From: Paul Cann
Sent: 24 July 2017 11:05
To: Planning.Responses
Subject: RE: Planning Consultation on LU/163/17/DOC

APPLICATION NO: LU/163/17/DOC

Site Address: Land adj Knightscroft Toddington Lane Littlehampton BN17 7PP

Description of Works: Application for approval of details imposed under planning application LU/131/16/PL relating to Condition No. 4 (Surface water drainage)

Scale	1:250	At original	A4
Drawing Number	1708/D1.2	Revision	-

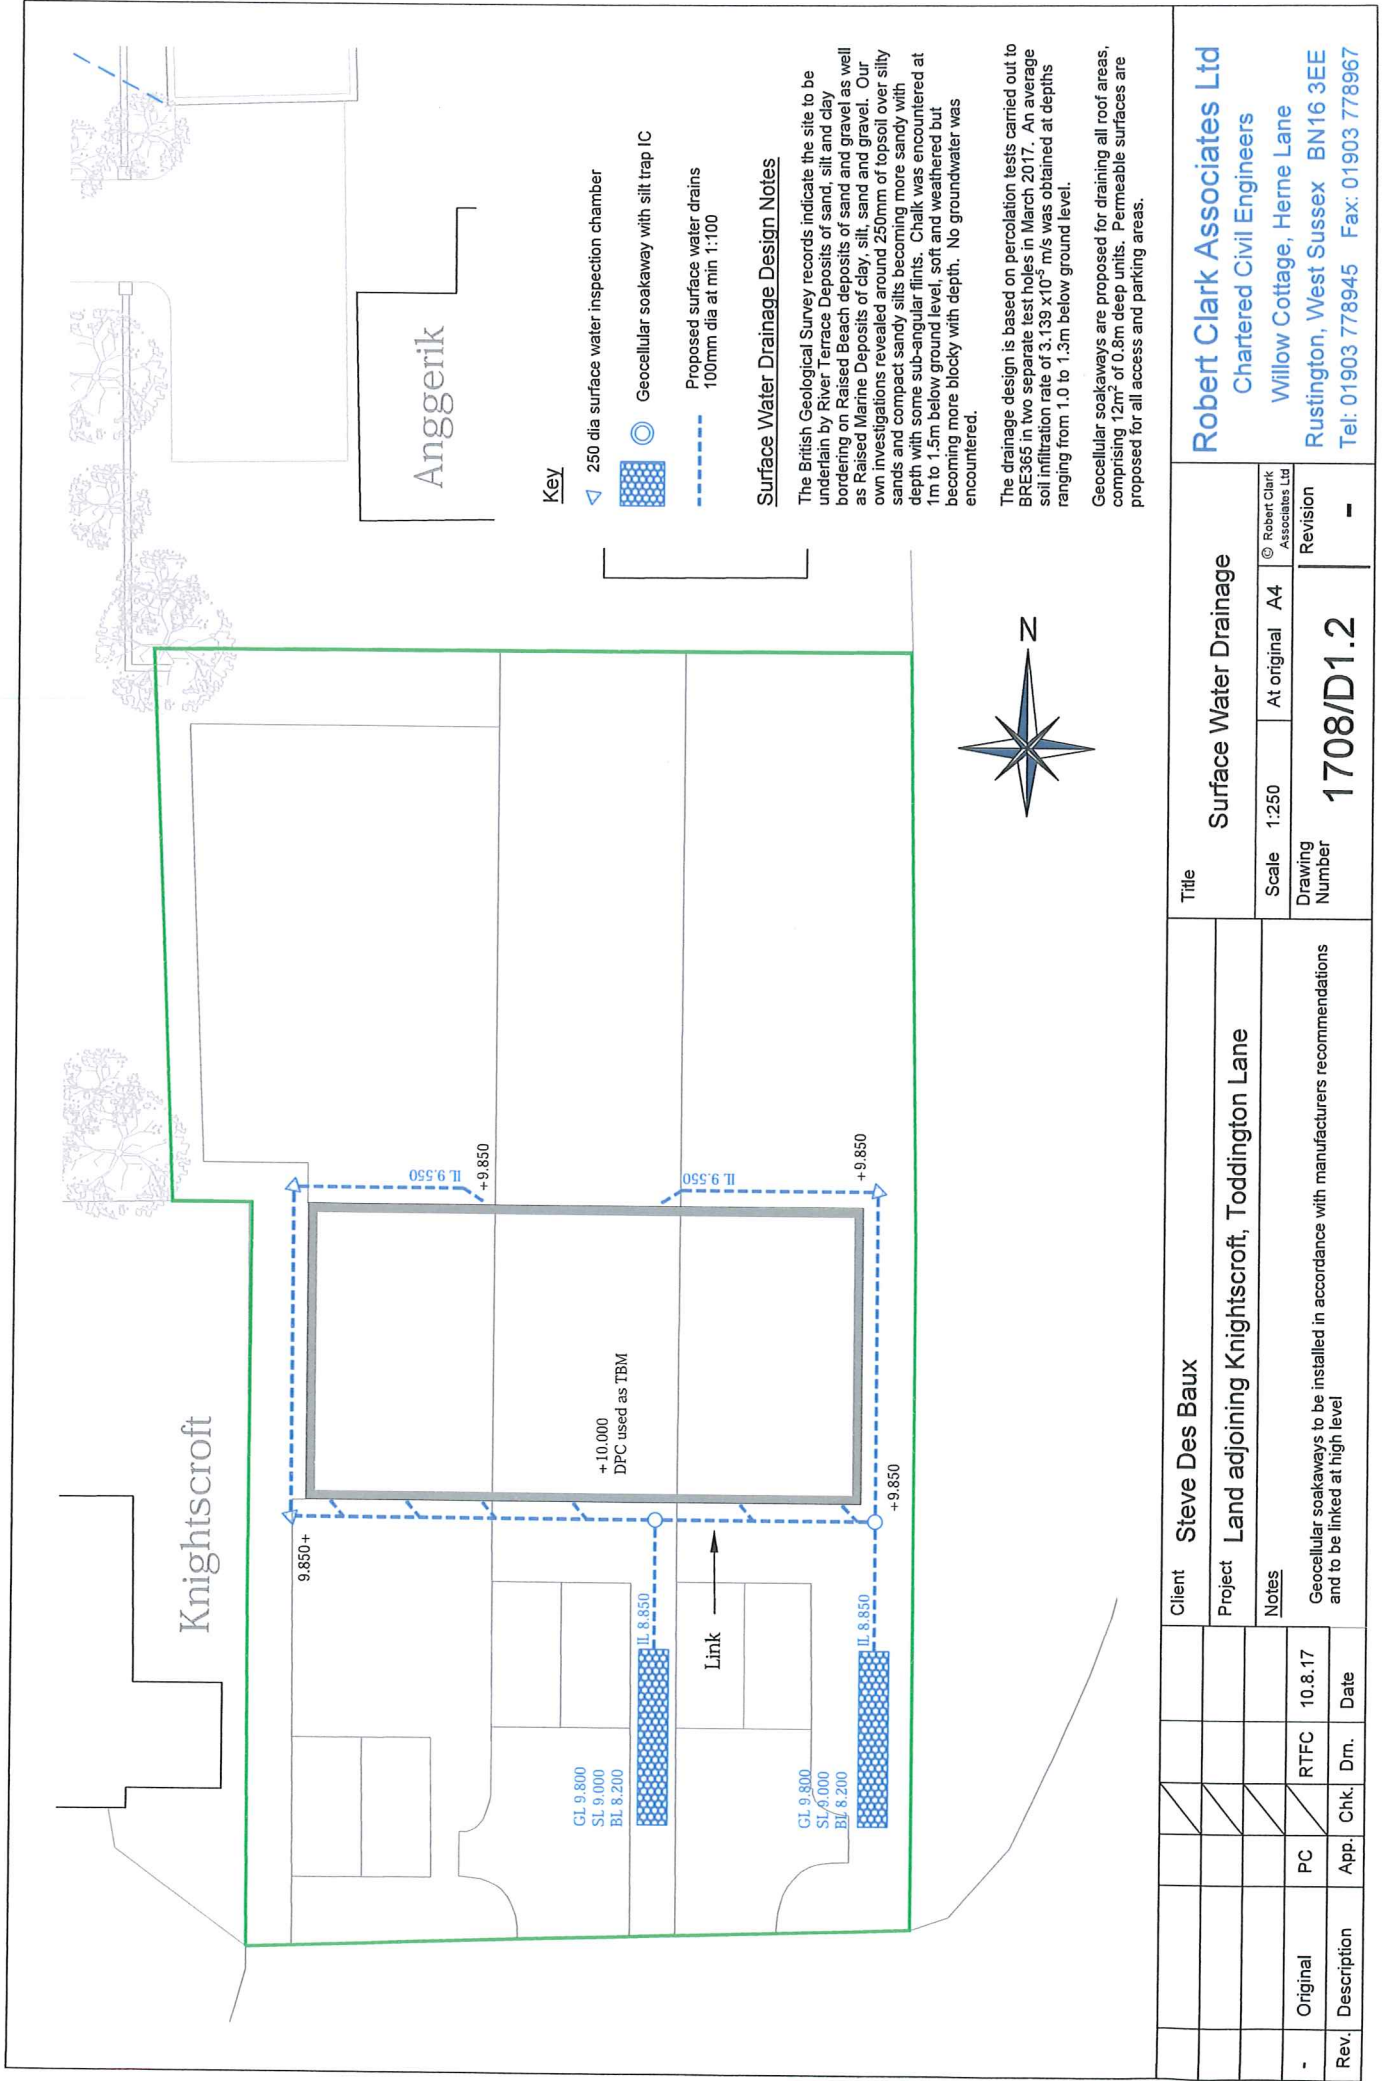
1. Details of winter percolation testing.
2. Hydraulic calculations for the design of the soakaways.
3. Drainage layout drawing needs to include base level and top of crate levels for the soakaways, also incoming pipe invert levels.
4. Construction detail drawing required for soakaways.
5. Drainage for the car parking/driveway areas also needs to be considered.
